Application by Suffolk County Council for the Lake Lothing Third Crossing

The Examining Authority's written questions and requests for information (ExQ2)

Issued on 22 March 2018

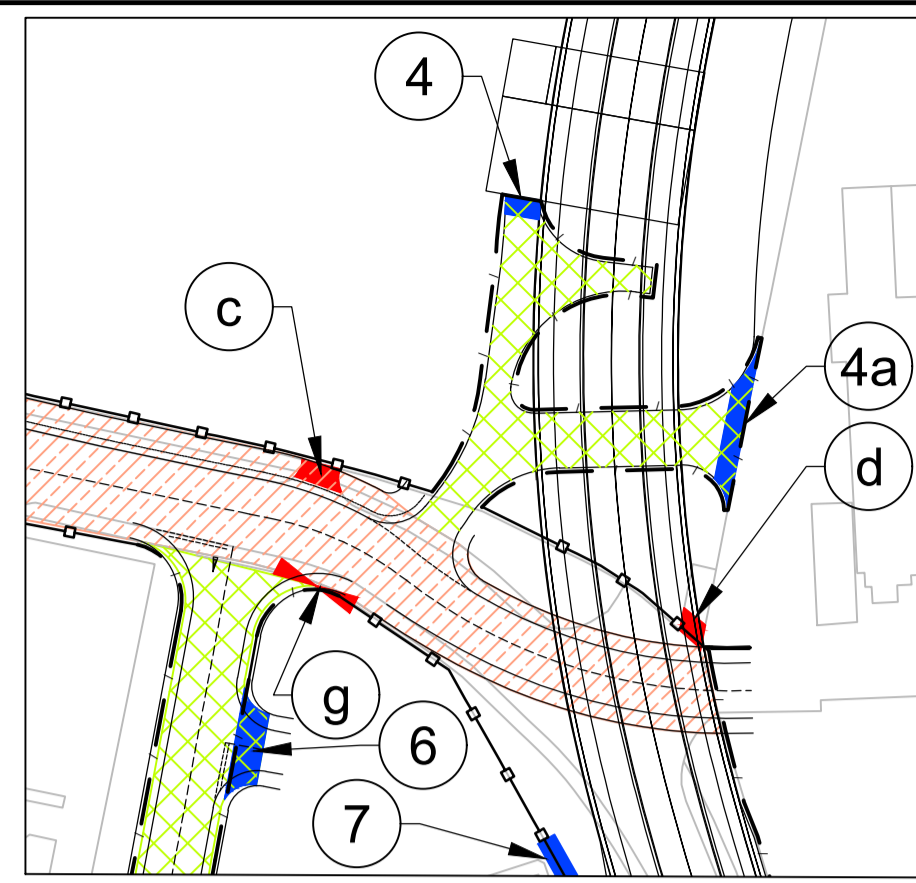
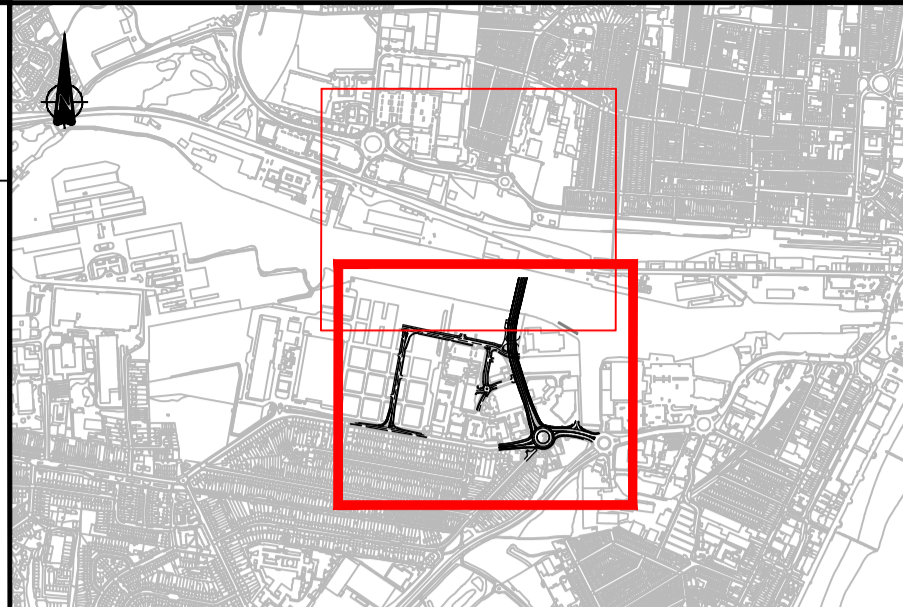
1.4	The Applicant	Why are there no extinguishment of easements, servitudes and other private rights plans provided with the application?
1.5	The Applicant	The new Private Means of Accesses 10 and 11 shown on the Rights of Way and Access Plans Sheet 2 of 2 [APP-027] do not appear to connect to a public highway?
